Application # 1050023835B

COUNTY OF HARNETT RESIDENTIAL LAND USE APPLICATION

PROPERTY LOCATION: Subdivision: Pine Branch Lot #: 59 Lot Acreage: .50 Acre

Regarding: More Branch CT 59

TED BROWN CONSTRUCTION, INC.
 THE PG13-A04BF
 LOT # 59 MIRE BRANCH
 SCALE: 1"=40'

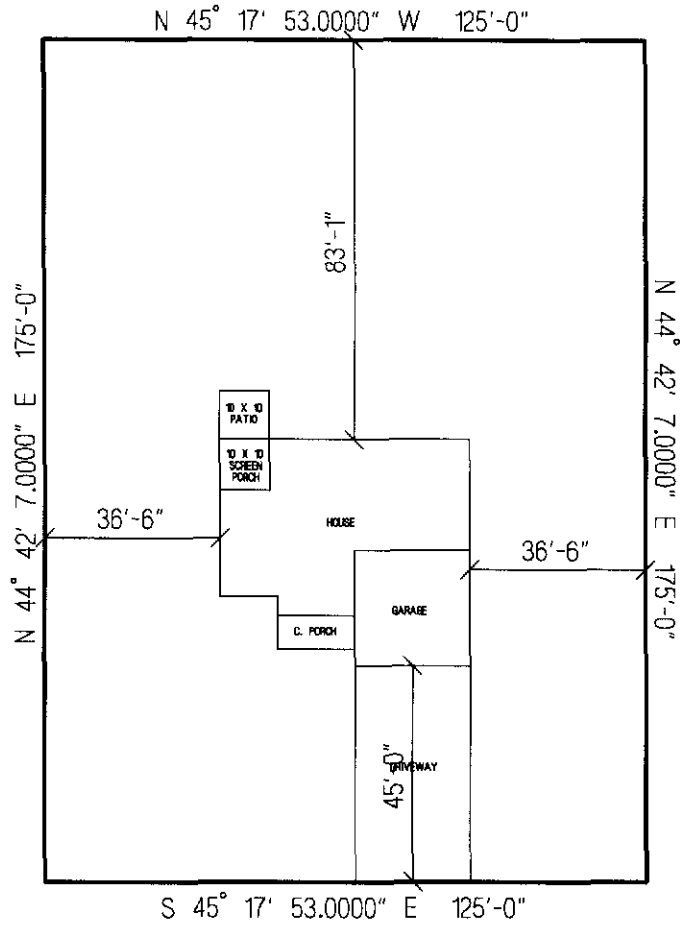
House needs to be moved 8' left or 10 feet closer to road. Either should allow this to fit!

Shift house 8' left (24'6" from left side line)

Matt needs to submit new plot plan
